Our Ref: Y/86/17/HH
Your Ref:

Town & Country Planning Act 1990 (as amended)
Town & country Planning (Development Management Procedure) (England) Order 2015
Application for Planning Permission for Works or Extension to a Dwelling

Development Convert existing garage into habitable space & pitched roof to existing garage & utility room to replace existing flat roof.
Location 21 Downview Road Yapton

No. 62/17/01

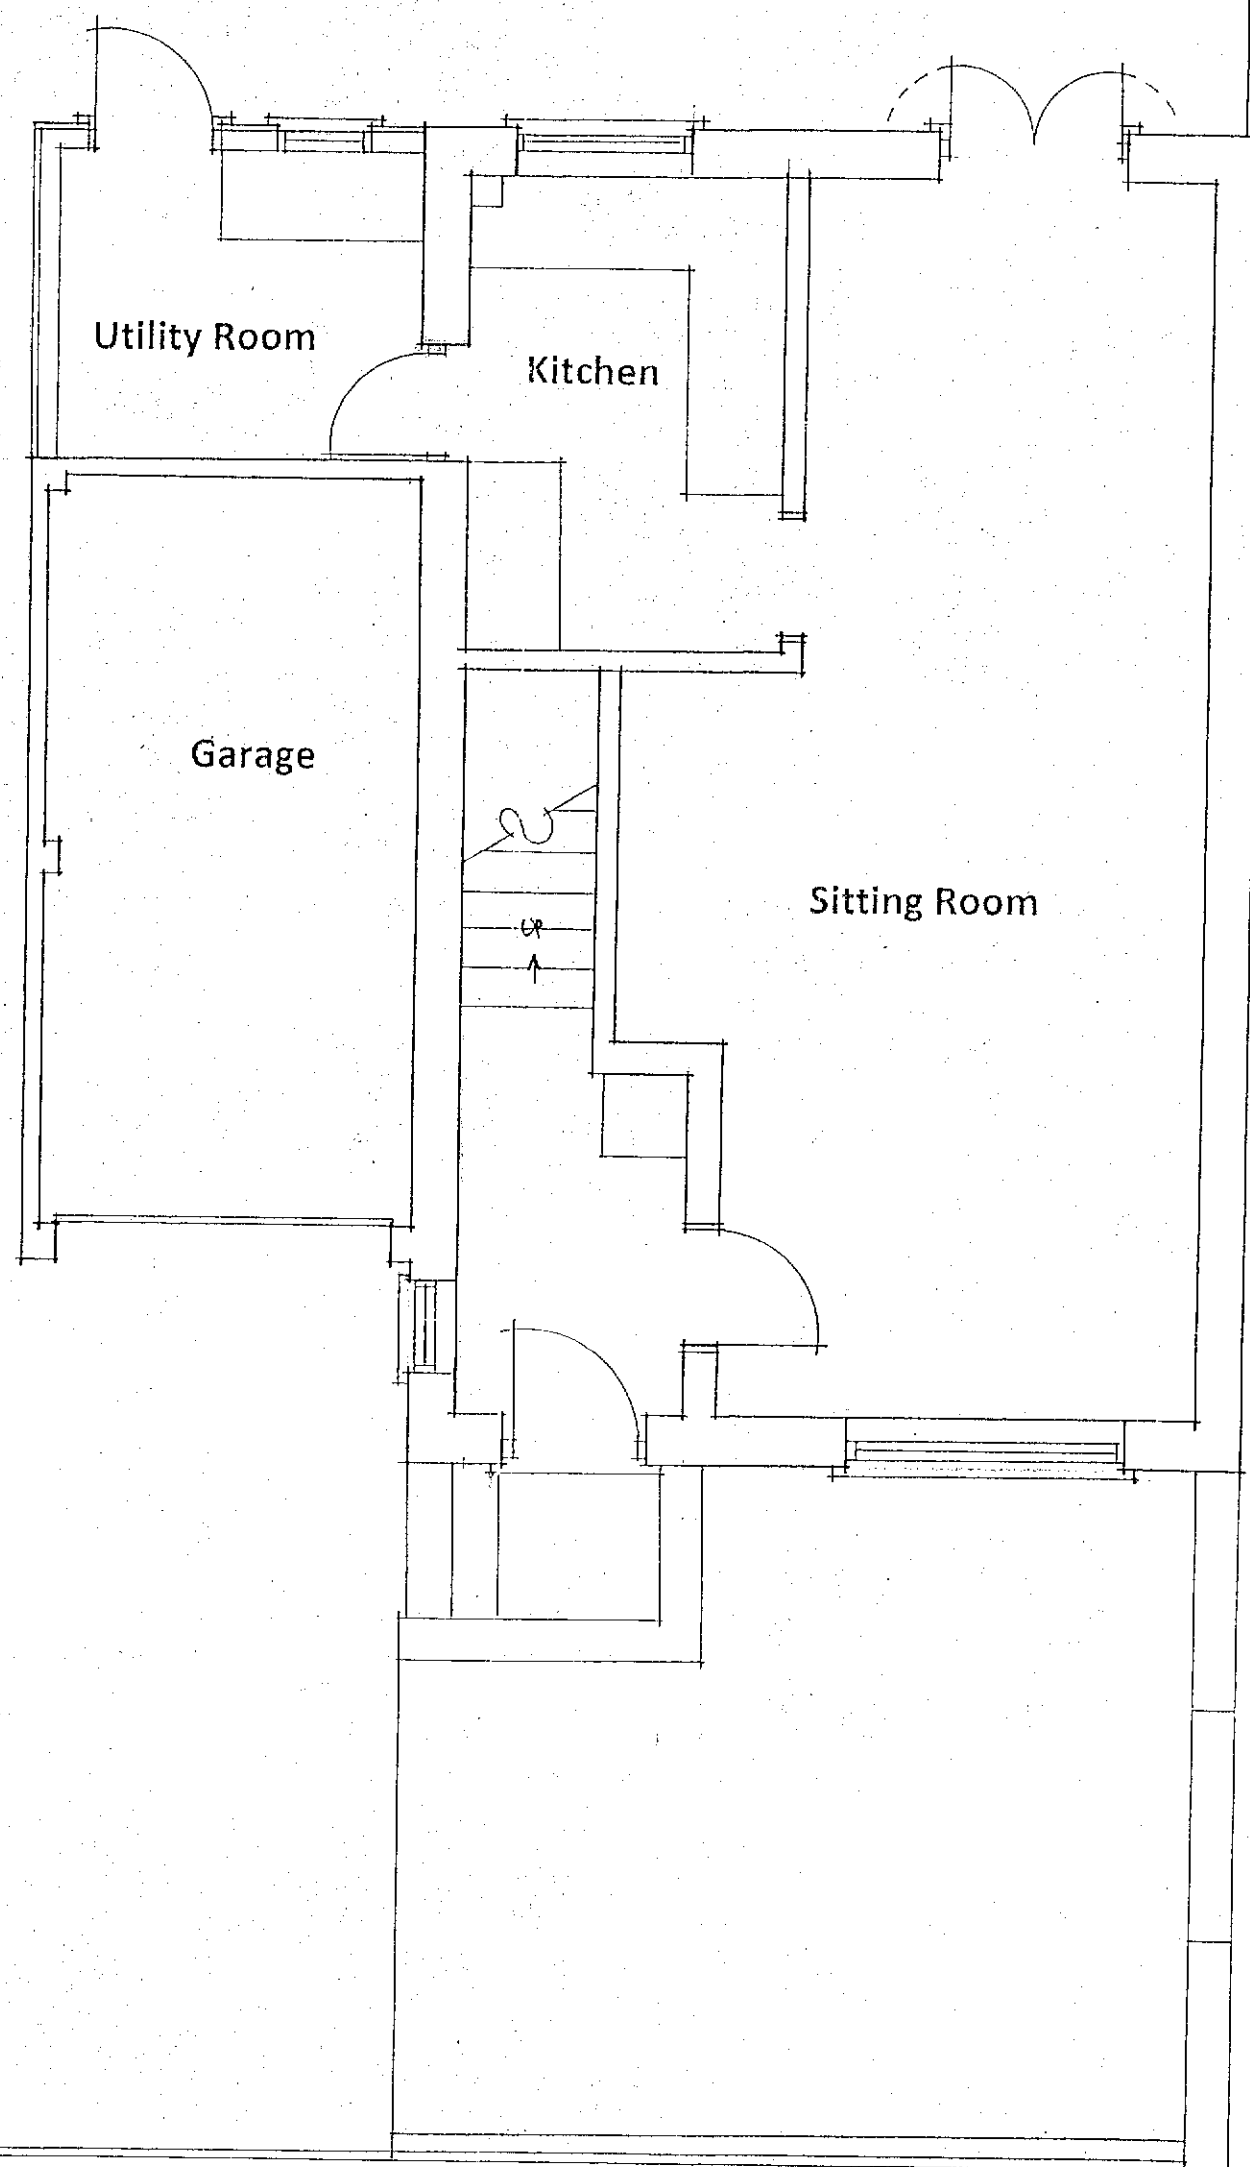
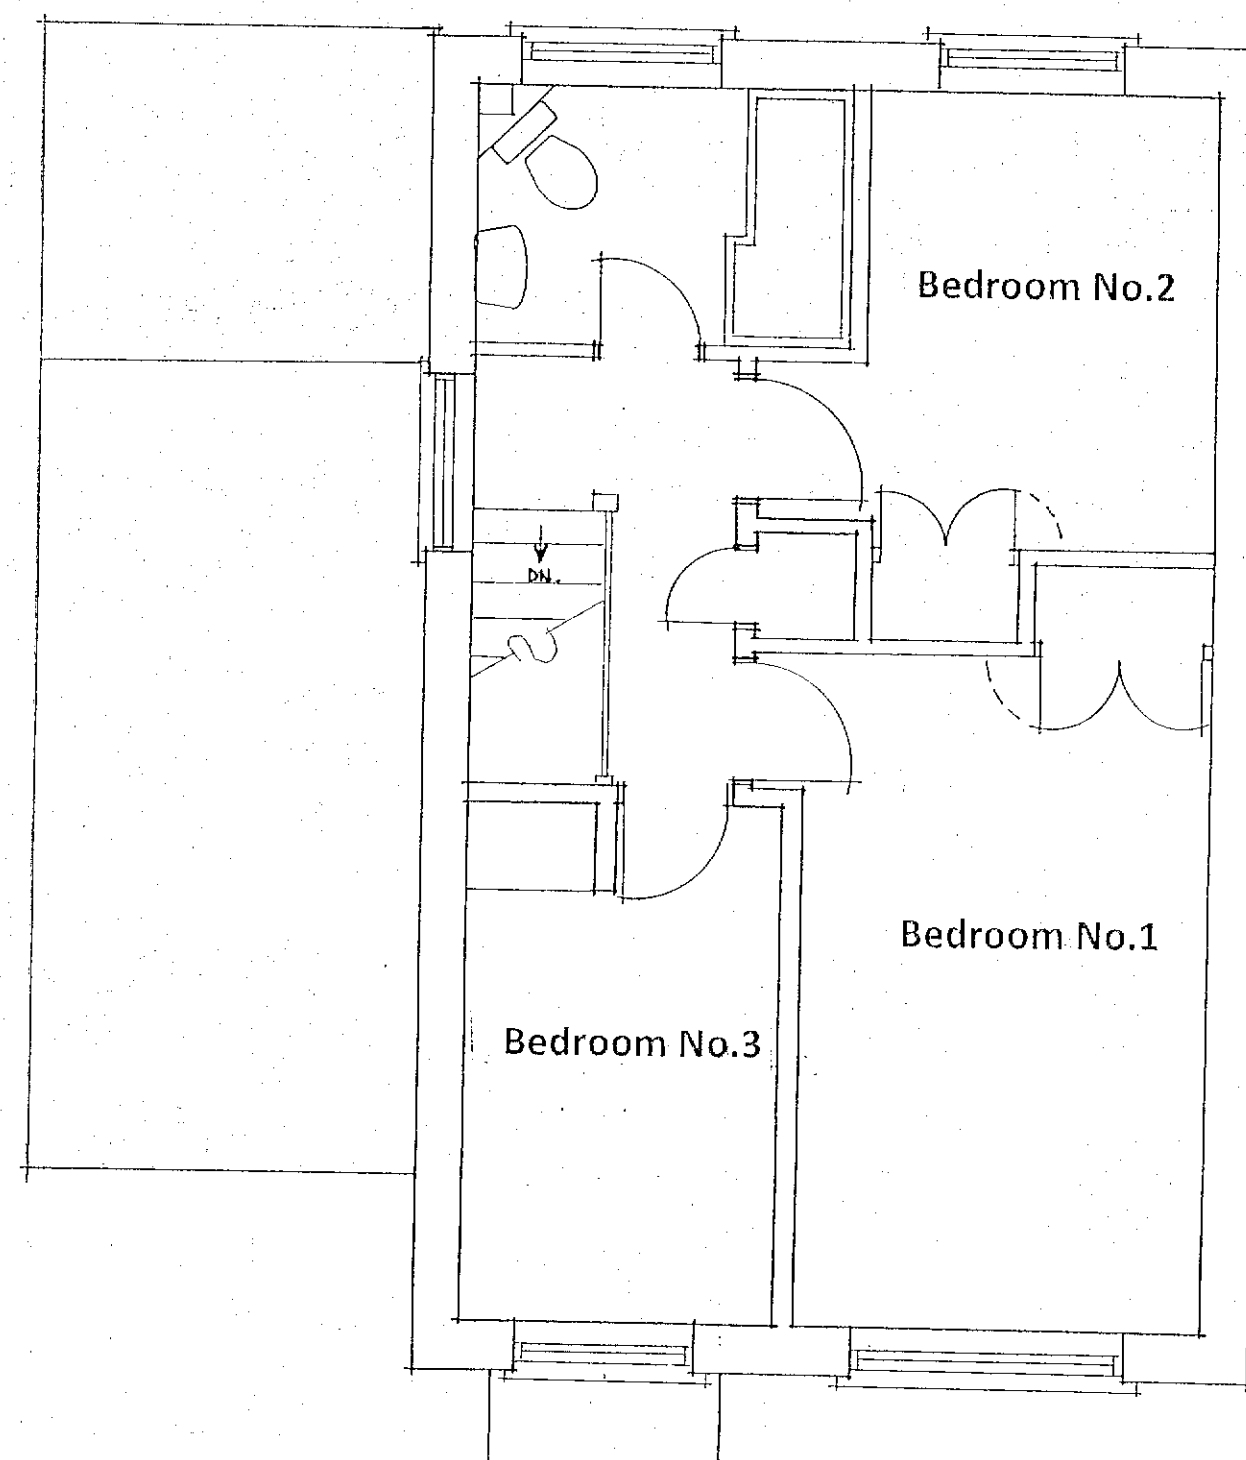
The existing first floor plan and side elevation do not accord. Please amend accordingly.
Lidsey Foul Water - Environmental Assessment
